LISTED BUILDING CONSENT REPORT**REF NO:** WA/63/09/L**LOCATION:** Little Box Cottage
The Green
Walberton**PROPOSAL:** Application for Listed Building Consent for alterations to existing annexe & construction of new glazed link to cottage and alterations to existing dwelling to include the addition of two airbricks and replacement joists.**SITE AND SURROUNDINGS**

ARUN DISTRICT COUNCIL				
No.	WA 63	09	L	
Received

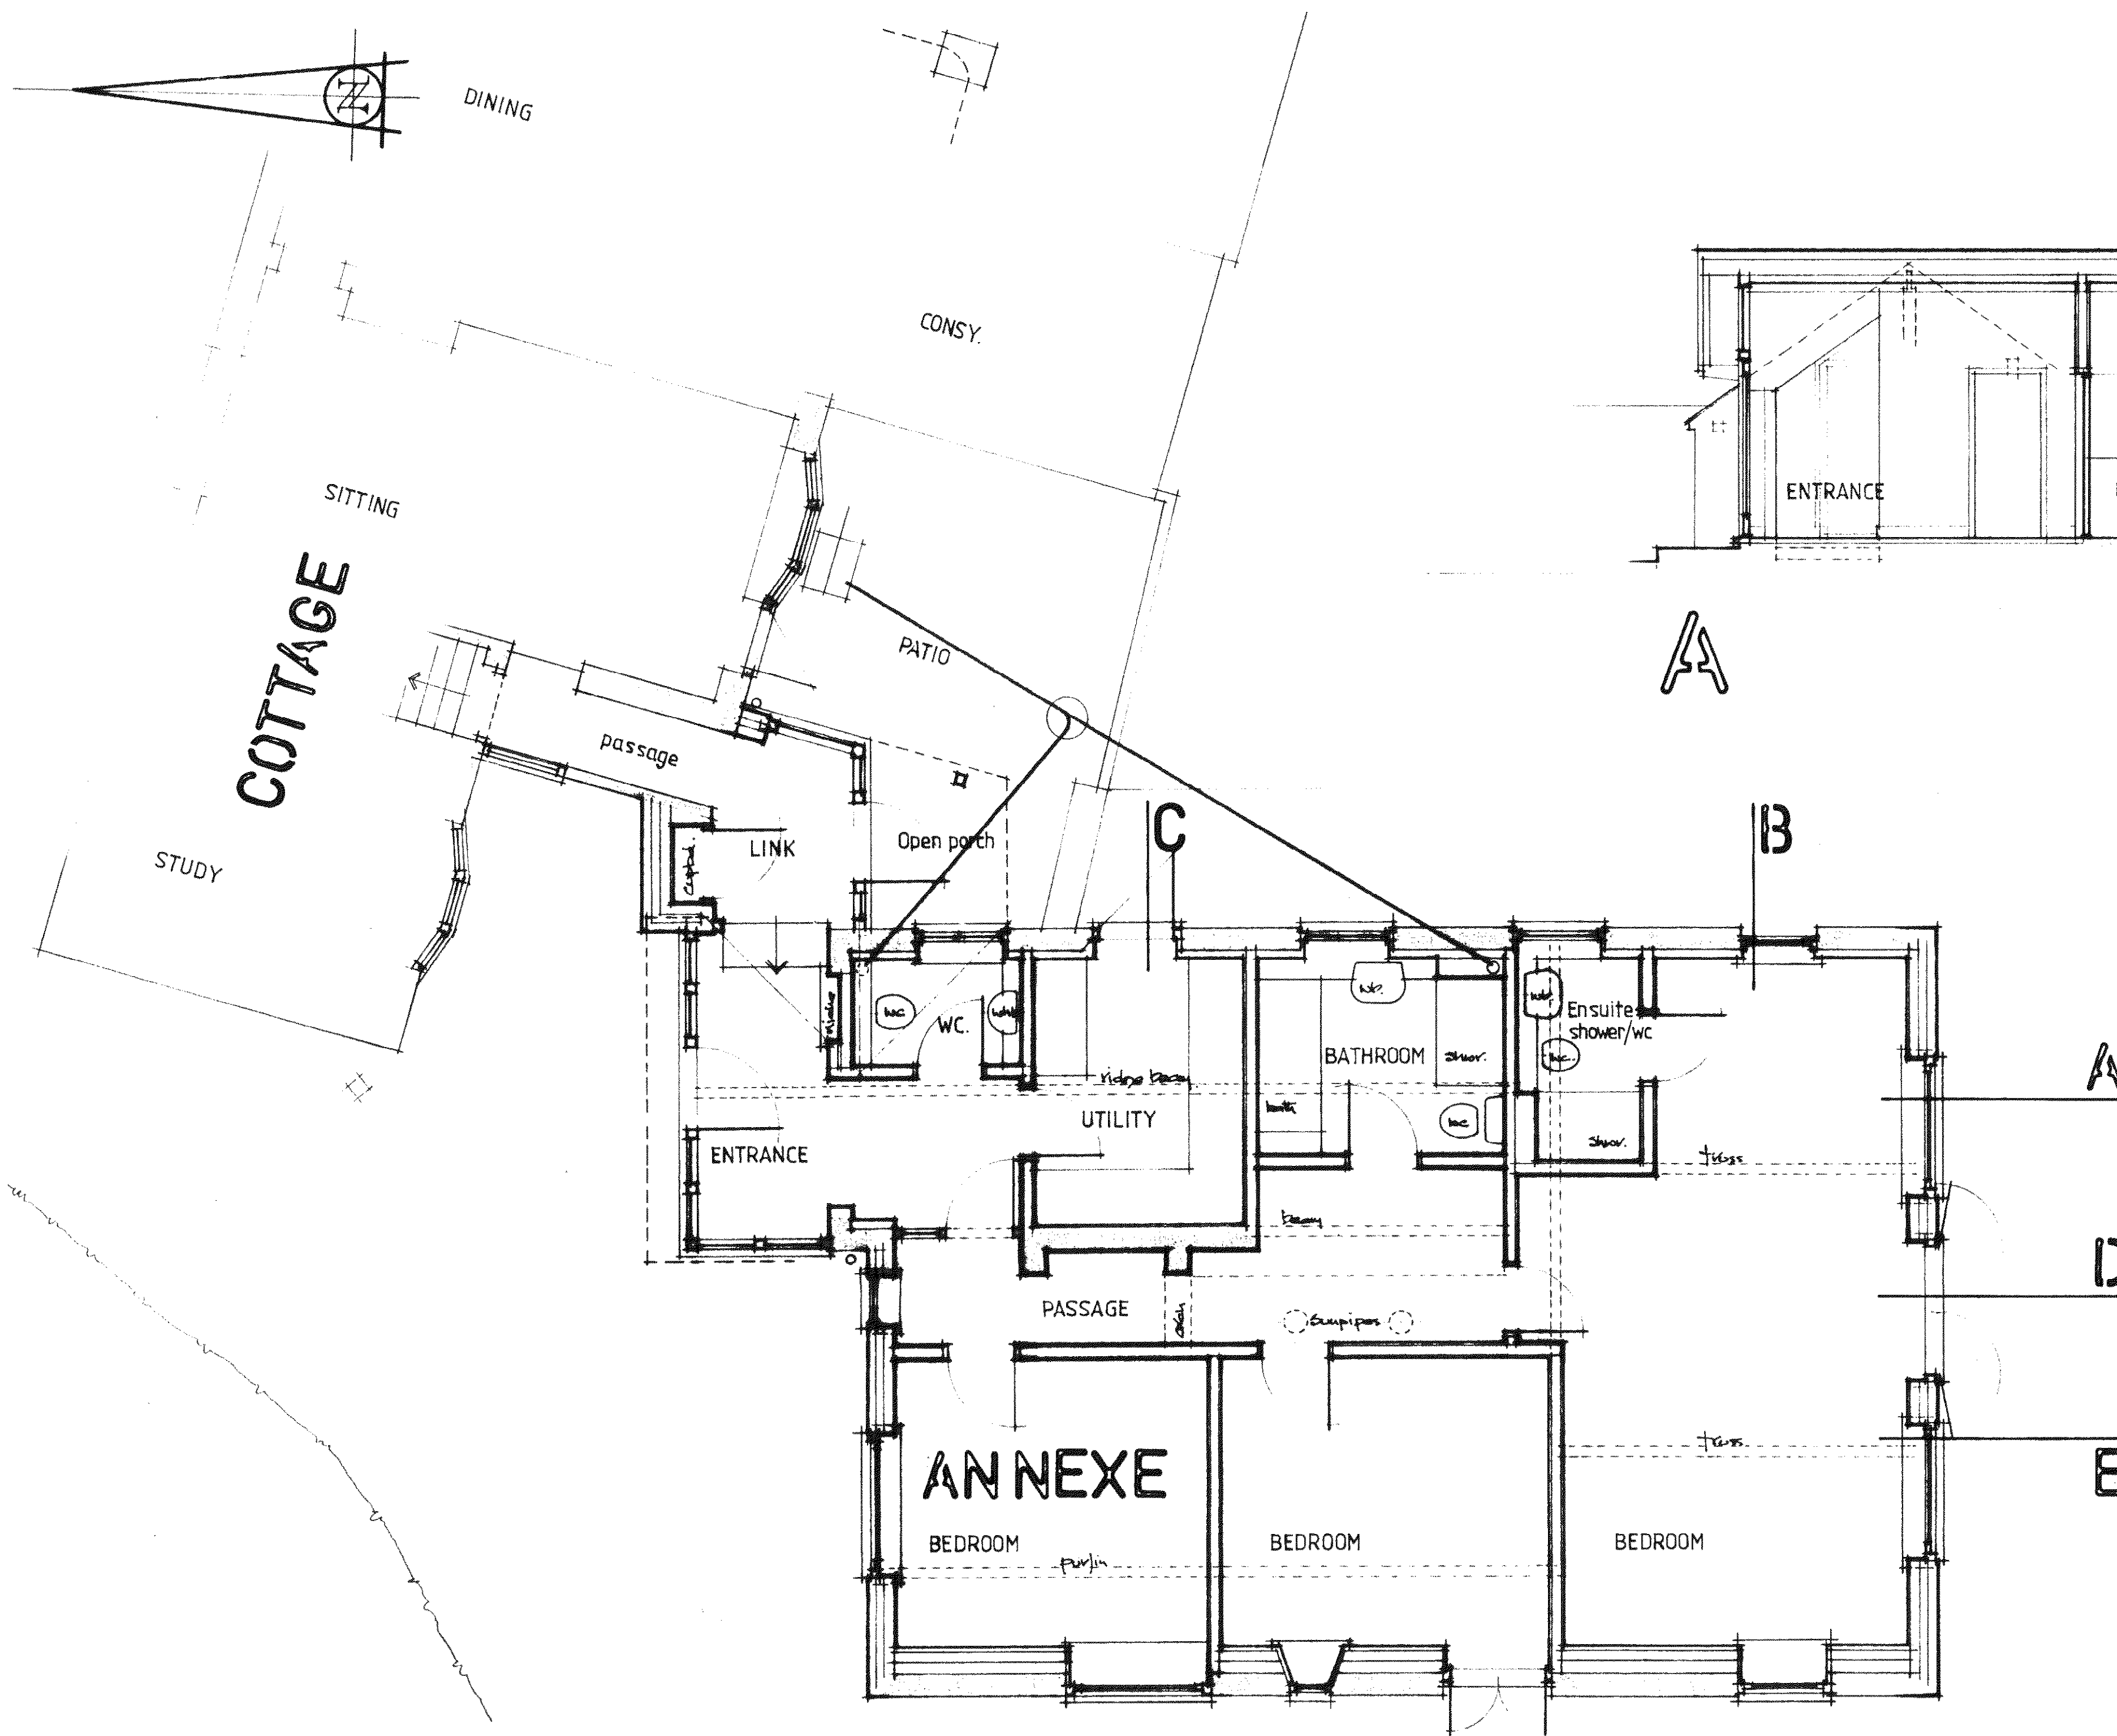
Comment: The quality of the drawings does not allow one to see exactly how the glazed link will adjoin the thatched roof of the cottage and we would request that this detail is carefully reviewed by the Listed Building Officer. Reason - so as not to detract from the character of the Listed Building.

Noted. Please see the response from the Listed Building Consultant below.

I make these comments further to our site visit. The glazed extension to the rear of the house to link the substantial rear building is acceptable. This is because the rear addition to the Listed house is 20th Century. The introduction of two ventilation bricks is acceptable.

REPLACEMENT JOISTS & NEW AIR BRICKS
TO STUDY
LITTLE BOY COTTAGE, THE GREEN
WALBERTON BUILDING

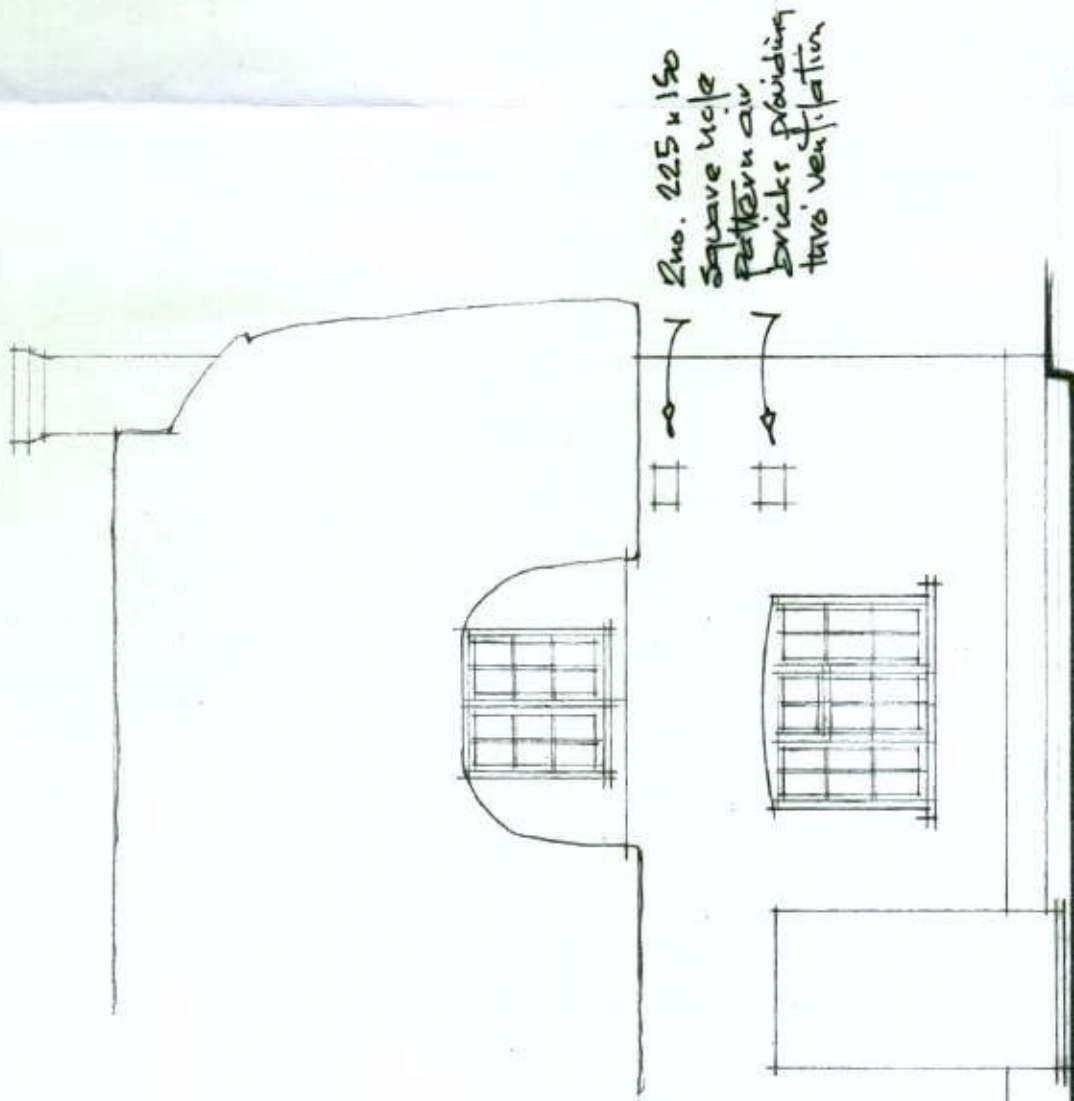
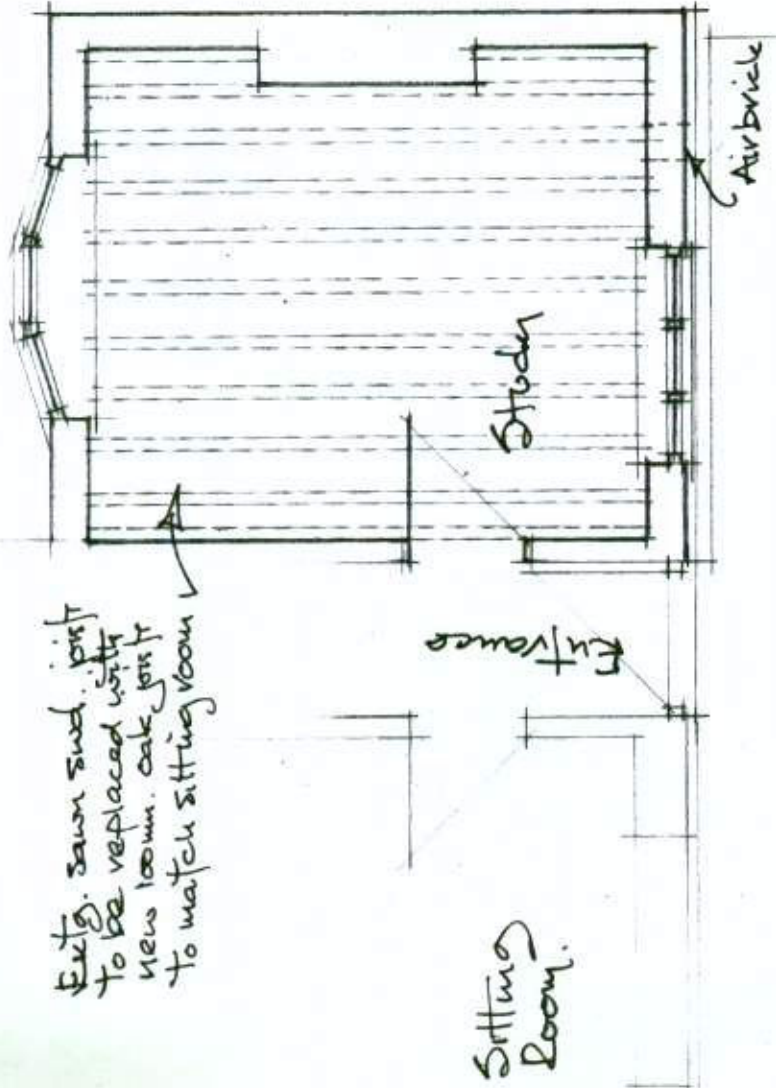
It is also proposed that two air bricks be inserted into the northern elevation of the building, due to a problem with damp, which is affecting the joists and beams within the property.
